Application for a non-material amendment following a grant of planning permission.
Town and Country Planning Act 1990

Extensions and alterations to existing property, including new roof terrace.

Resting of the proposed attached double garage.

Old plan/drawing numbers: 1070.02.c Proposed A1

Client: Mr J Marston & Ms J Marston	
Project Address: Easter Cottage The Thatchway Rustington West Sussex BN16 2BN	
Drawing Title: Proposed Floor Plans, Elevations, Roof Plan	
Drawing Number: 1070.02.e	
Scale:	As stated printed @ A1
Date:	16/11/2016

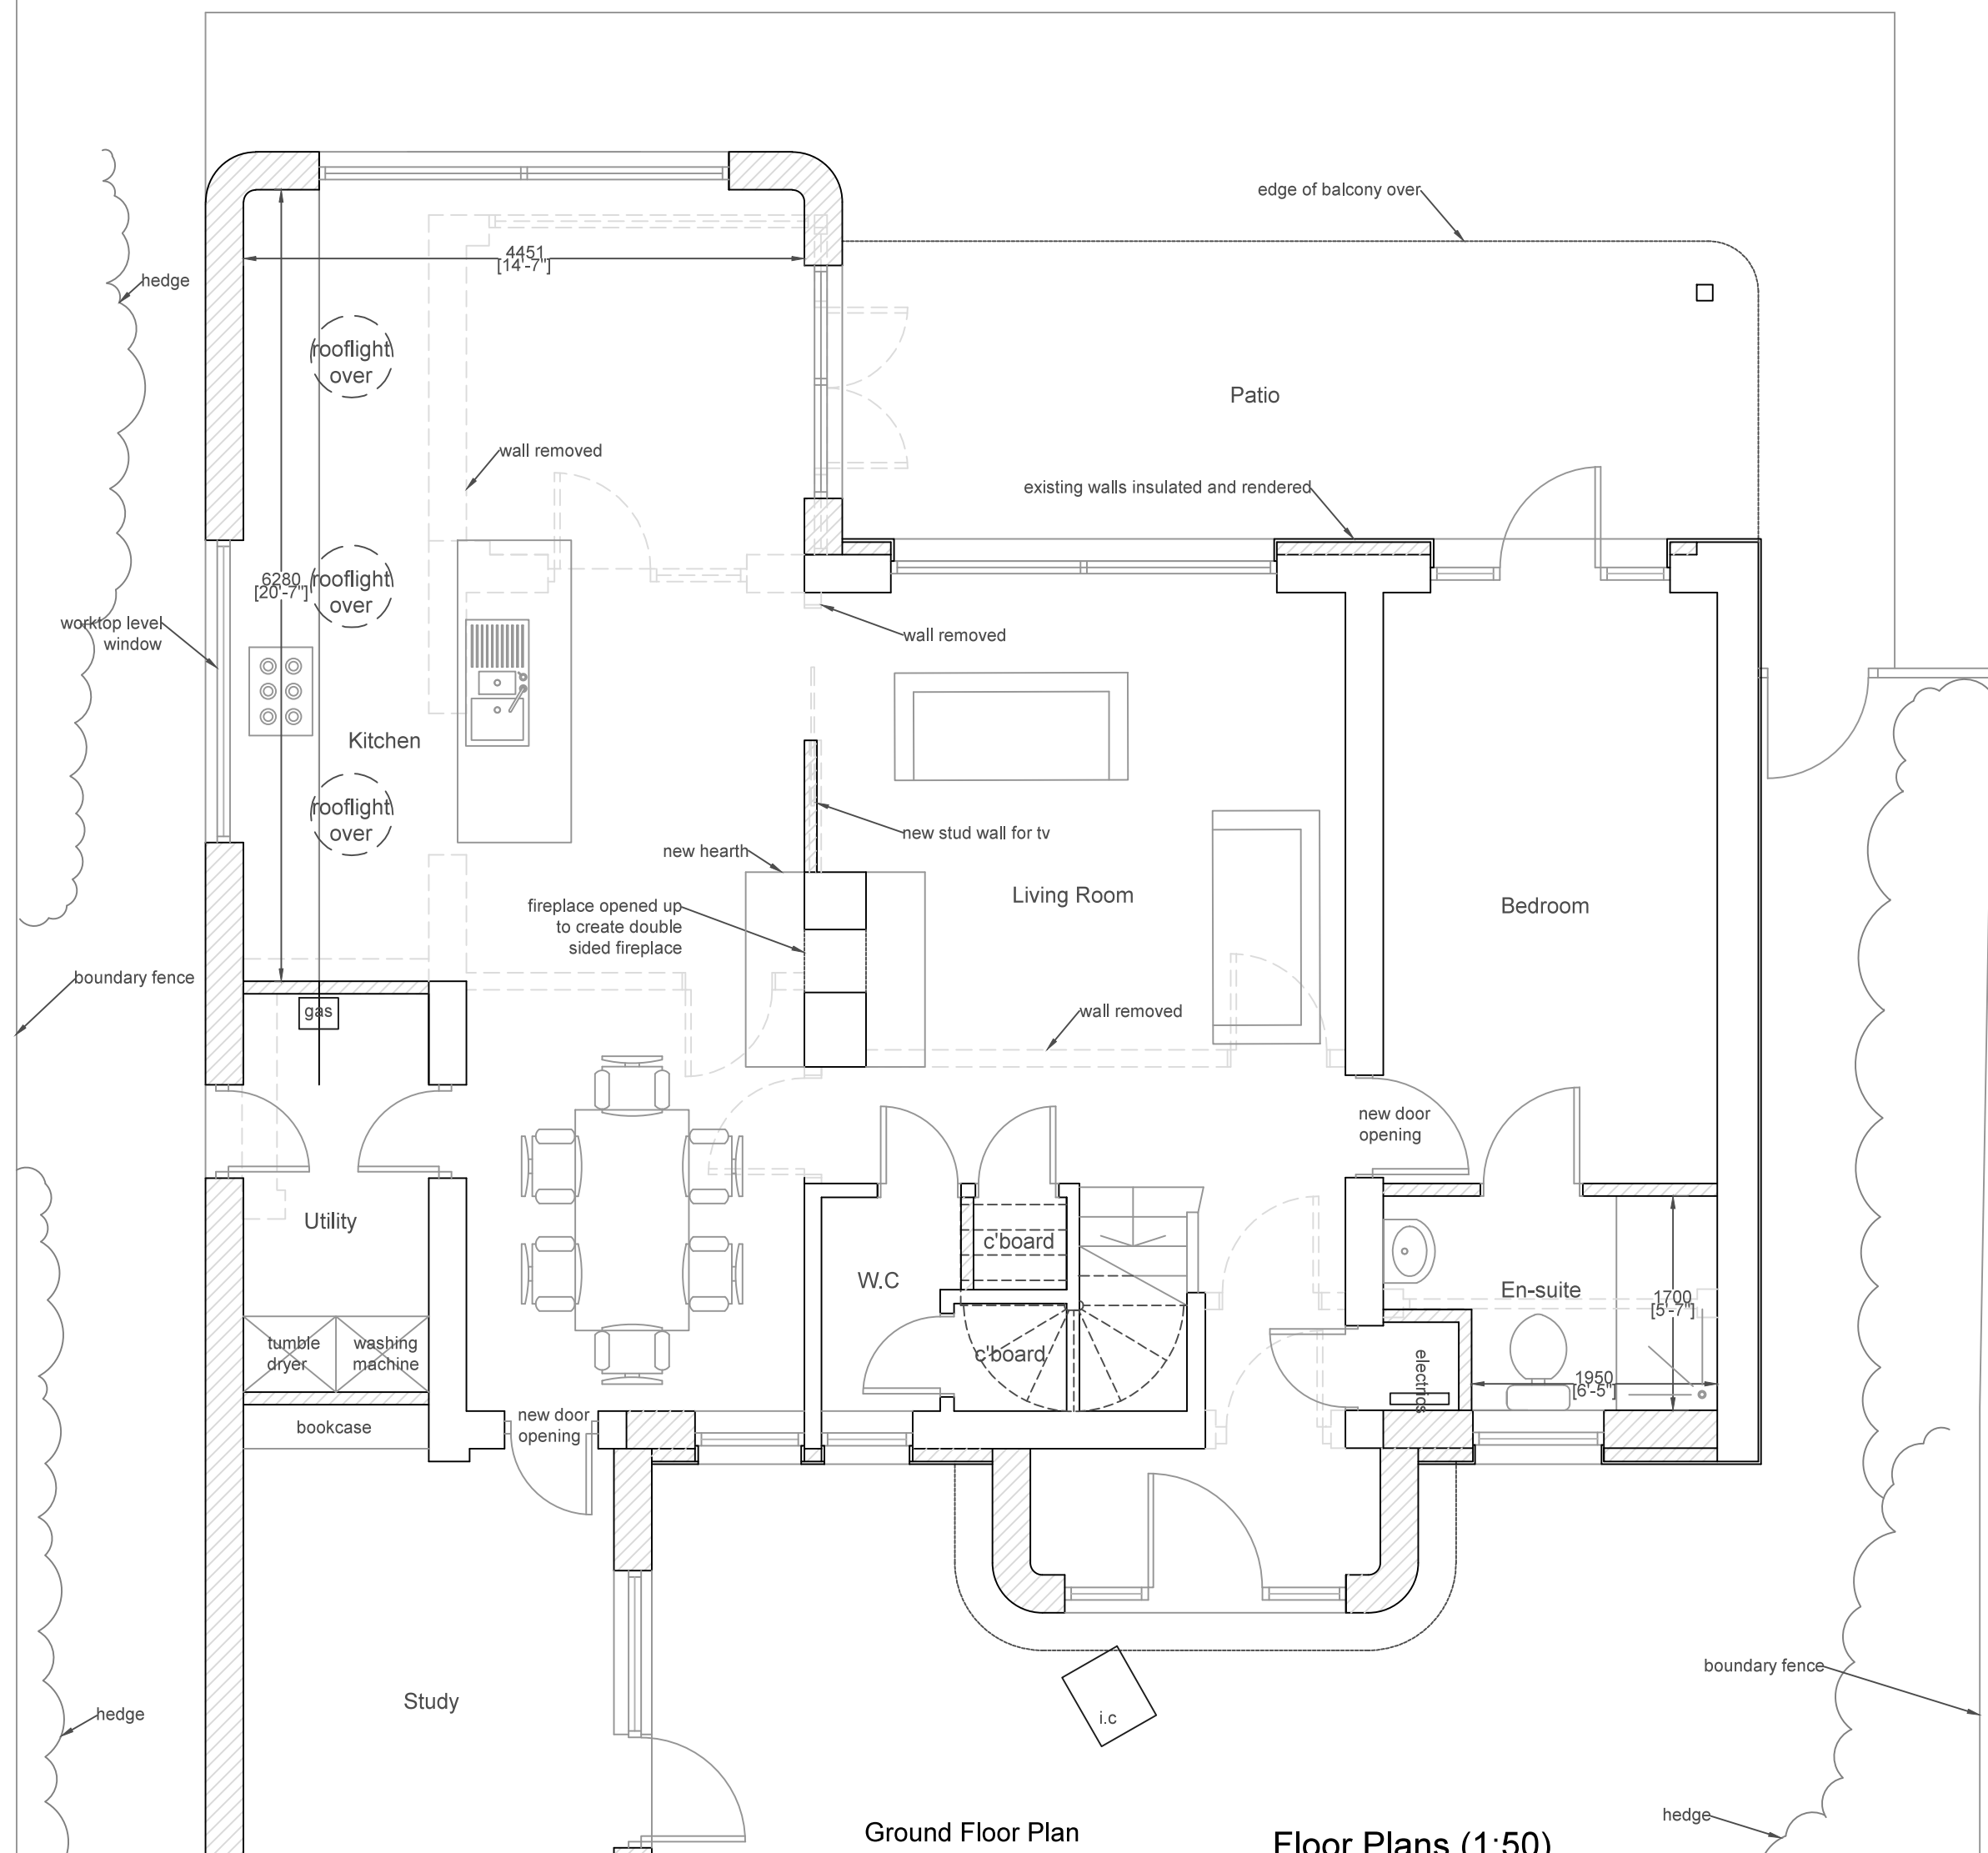
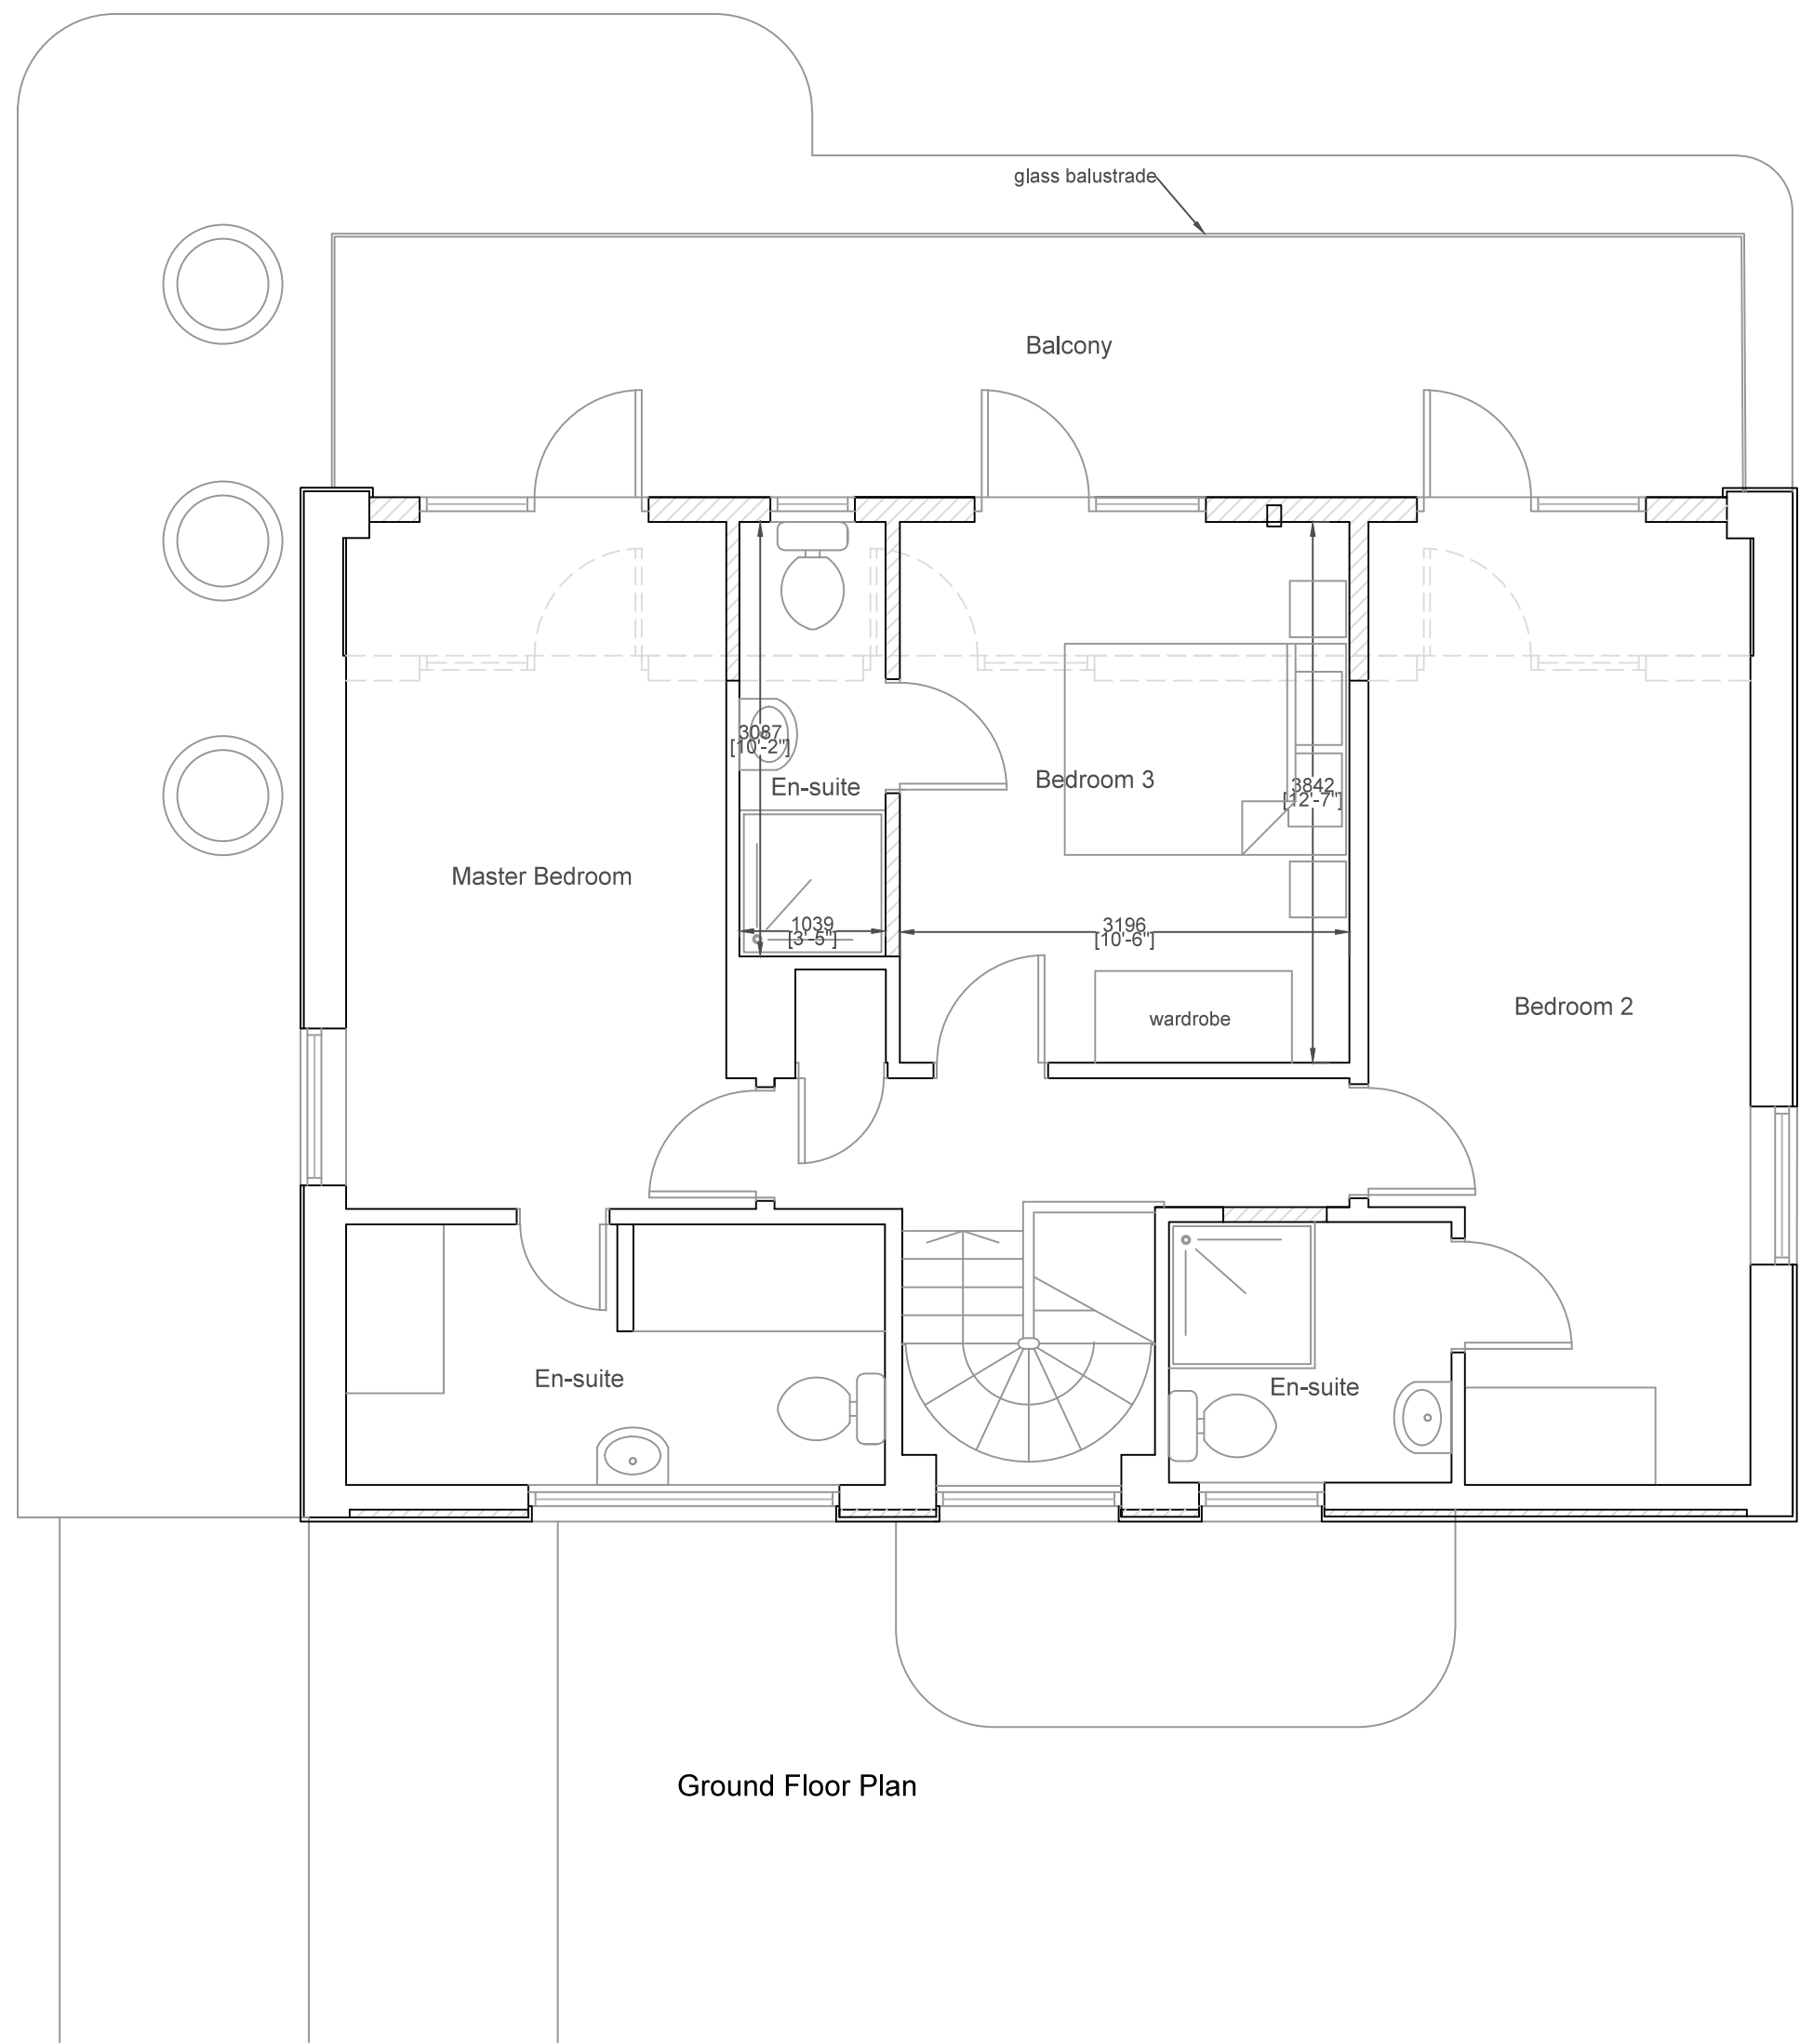
Access behind garage not required and moving the garage gives more space for parking to the front of the property.

New plan/drawing numbers: 1070.02.e Proposed A1
